Response to Comments, May 17 Email

Response to Comments, May 23 Email

1 ENLARGED FIRST FLOOR FIREWALL PLAN 1
 AE101 AE547 SCALE: 3/4" = 1'-0"

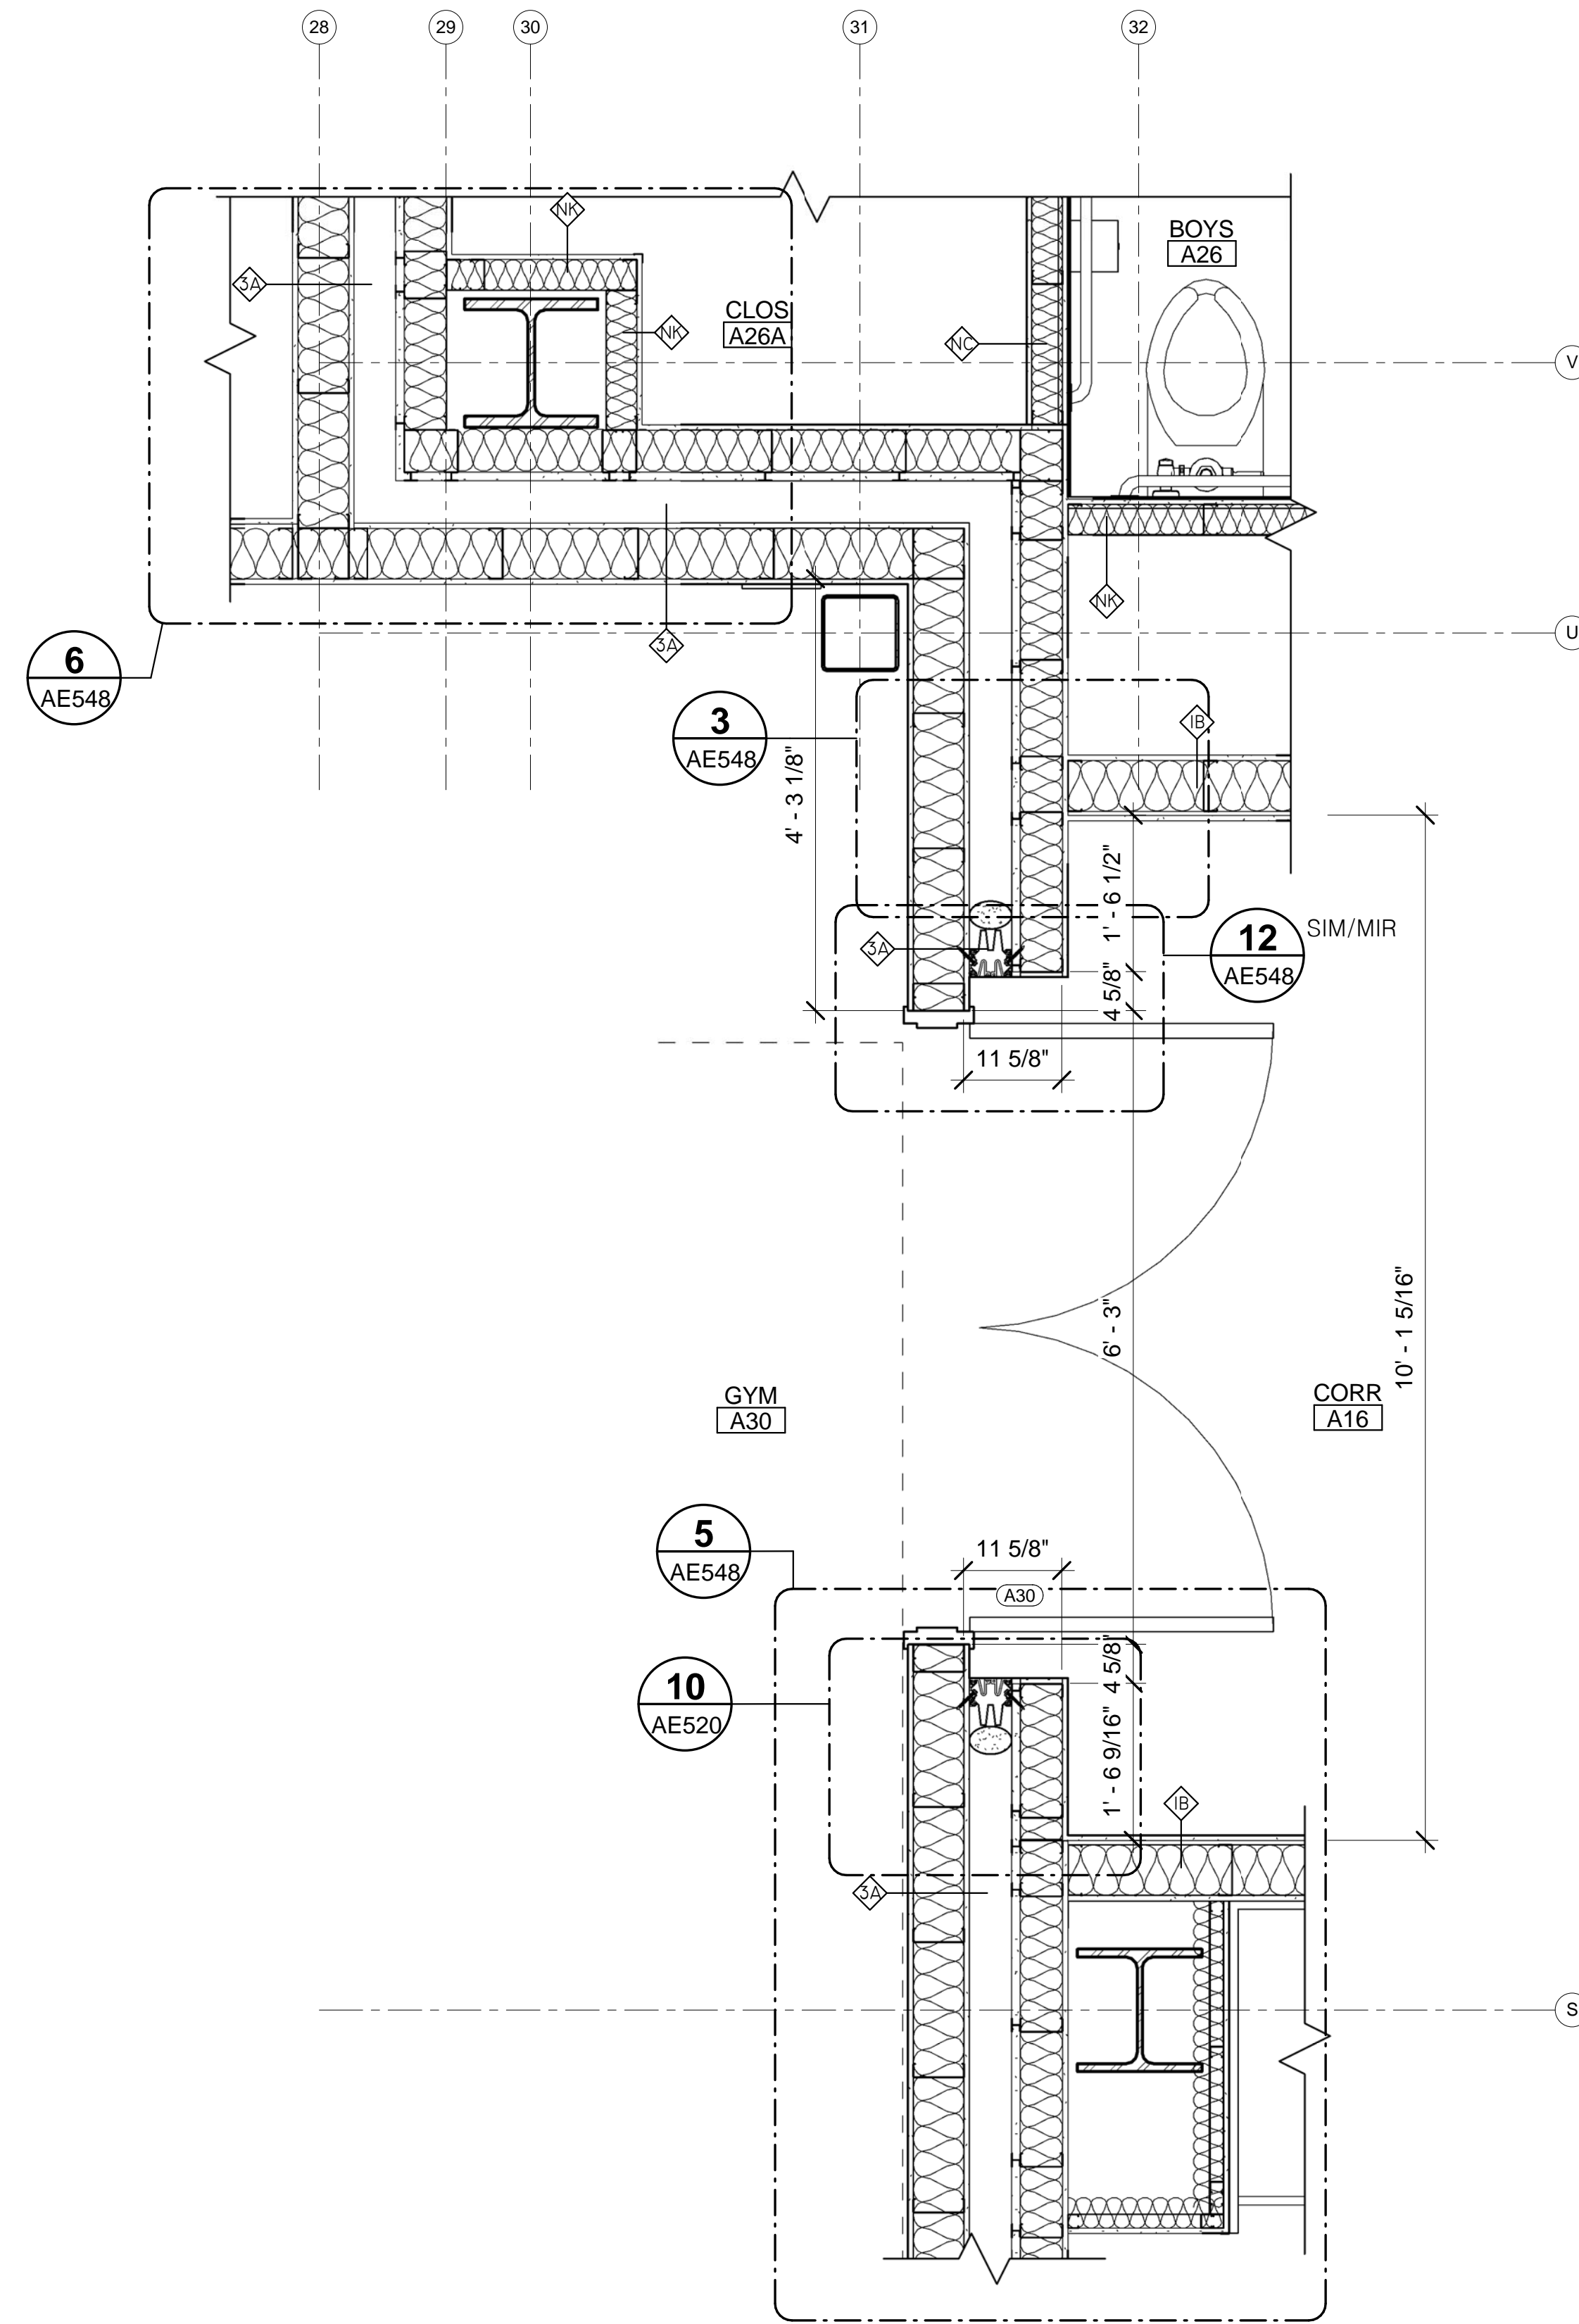
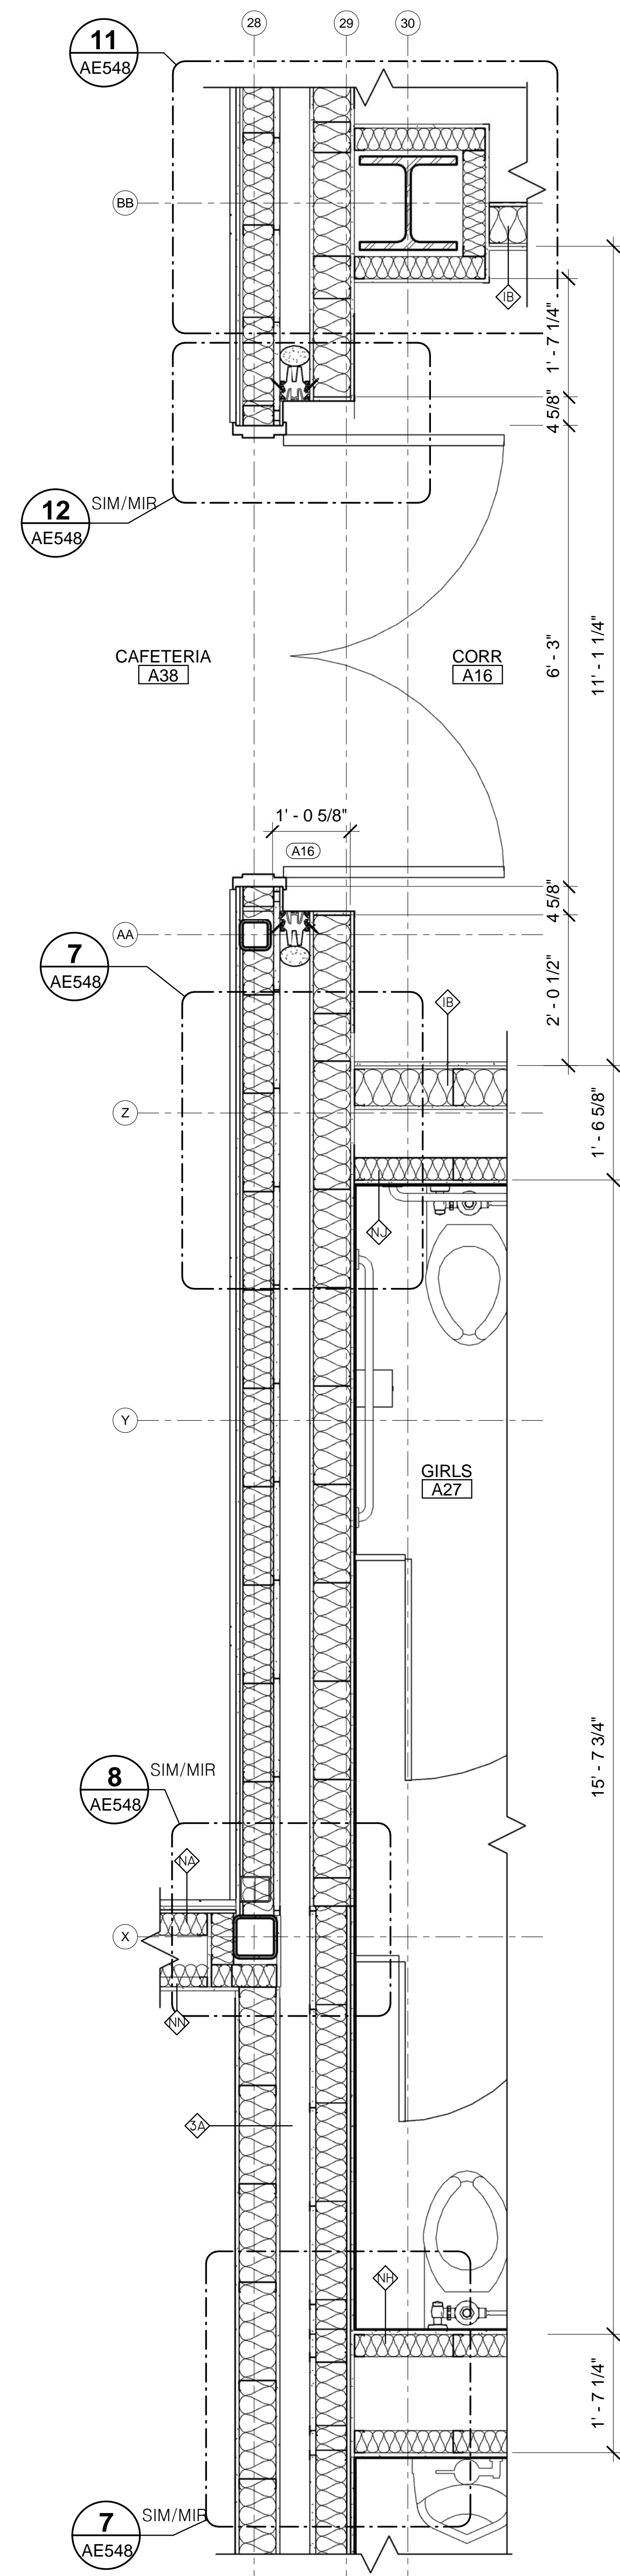
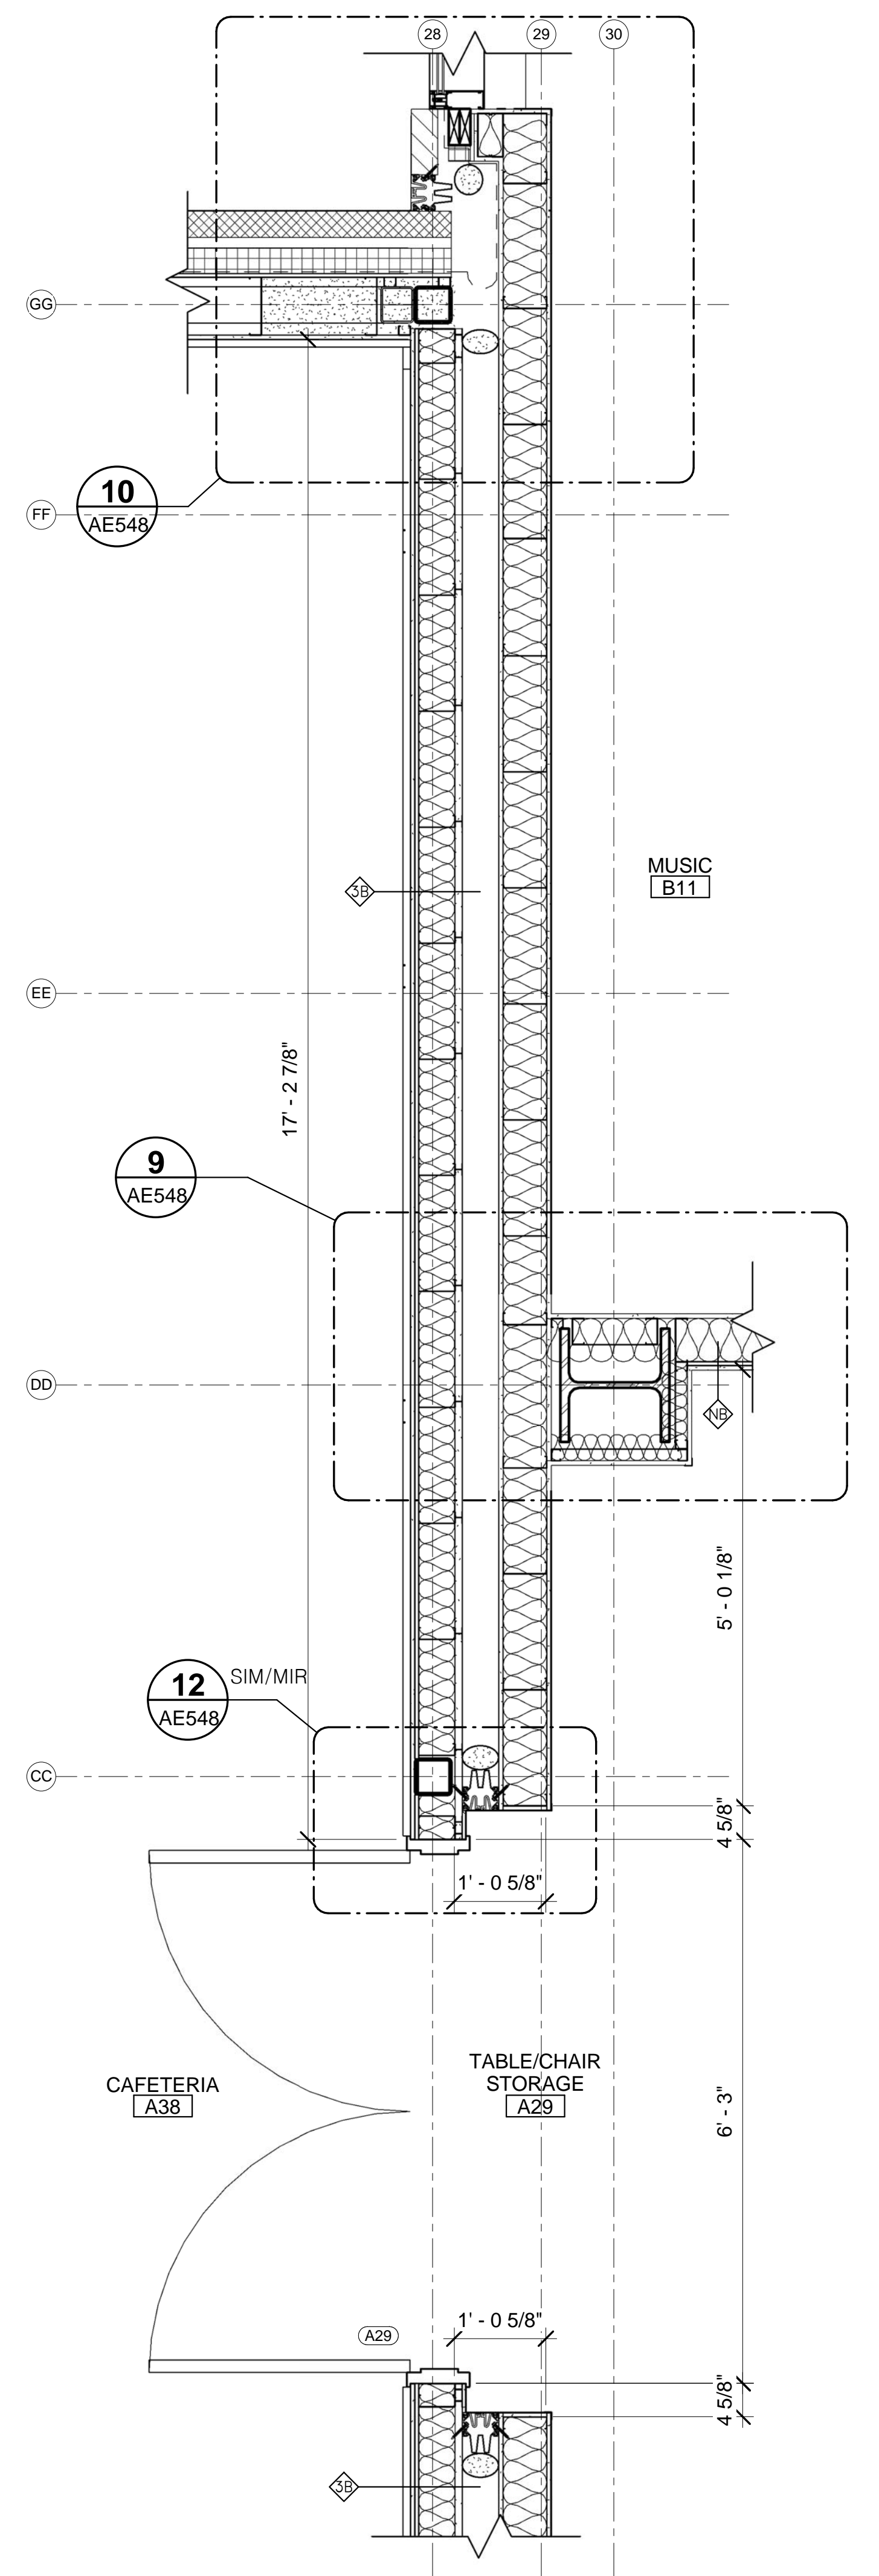
Q: I see that the two lobby areas are shown as fire walls. I do not see where the details are for the extension of these fire walls are called off. Please clarify the intent.

A: Fire wall details are located on sheets AE547, AE548 and AE549.
